What the committee approved — and why it matters now

Plot 23 and the cumulative effect of subsequent changes

Application: 2026/91657	Subject: Committee-approved safeguards and subsequent departures
--------------------------------	---

Front/south east facing elevation (1:100)

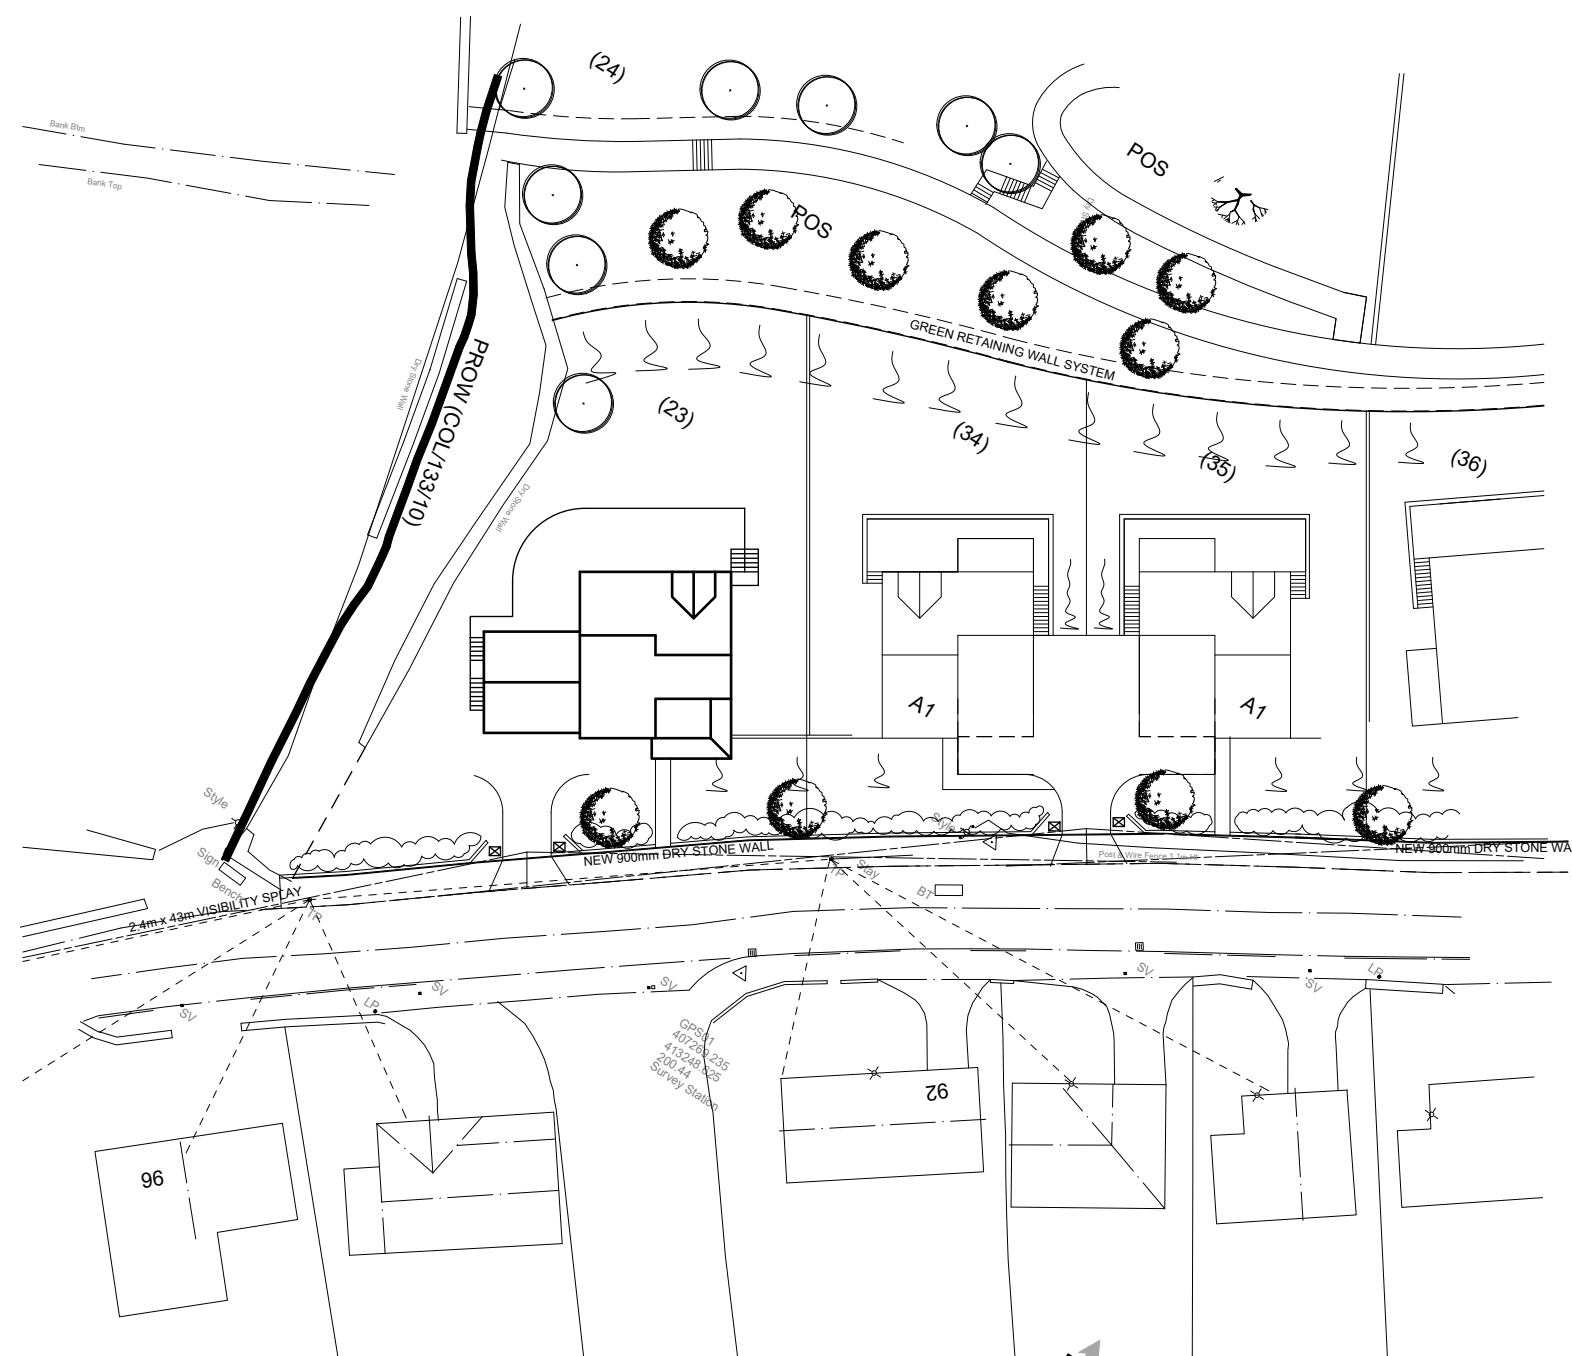
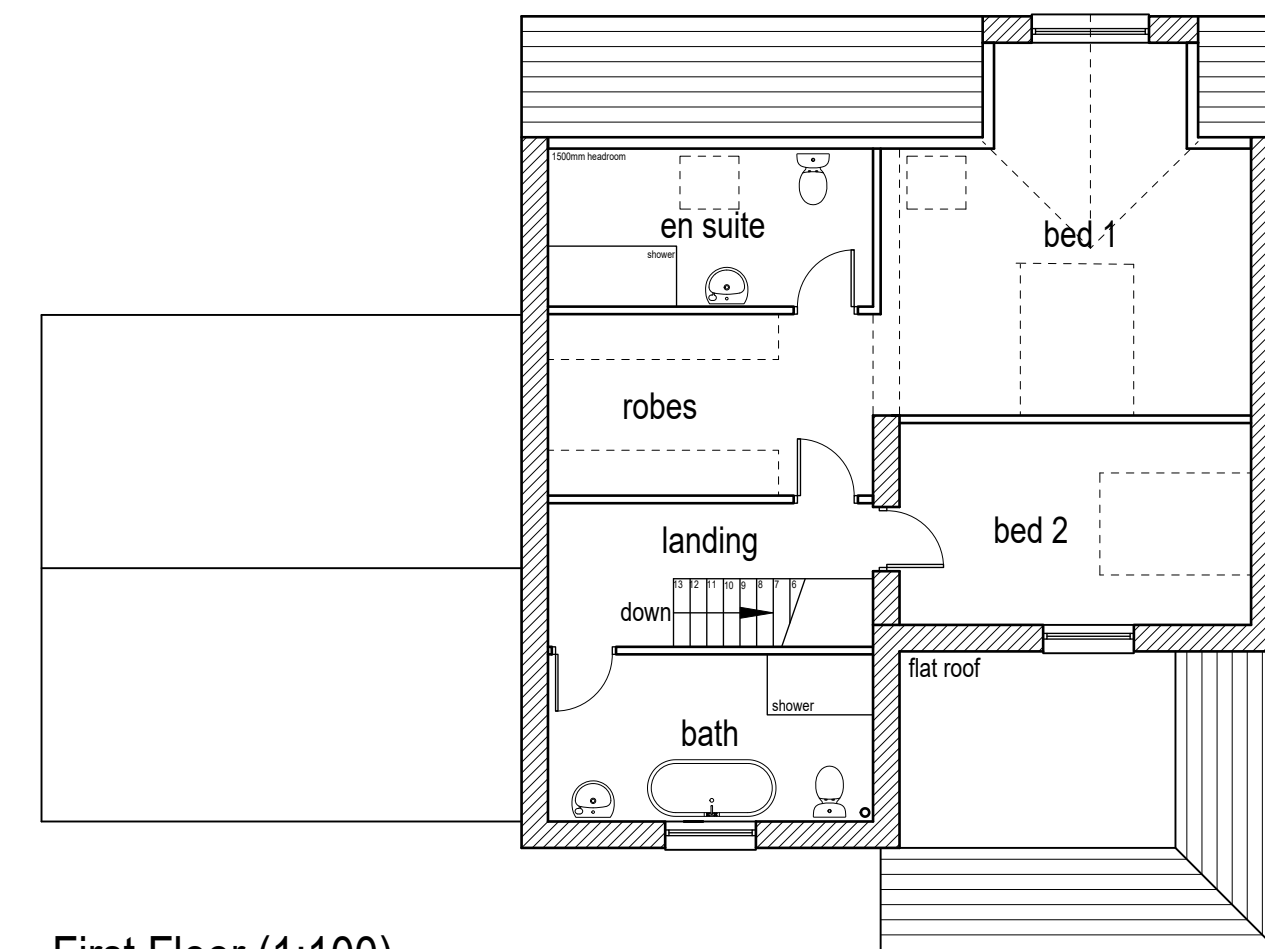
Plot 23 is now approximately 1 metre higher than the approved level, subject to final verification of the precise discrepancy. Its enlarged frontage, garage wing and lower-ground store and garden-room arrangements create four visible and functional levels when viewed downhill. That outcome cannot properly be treated as a minor alteration to the two-/three-storey landform strategy presented to the committee.

The side garage also introduces an additional roof element. Unlike the earlier integrated arrangement, it widens the built form and adds to the apparent mass of the frontage.
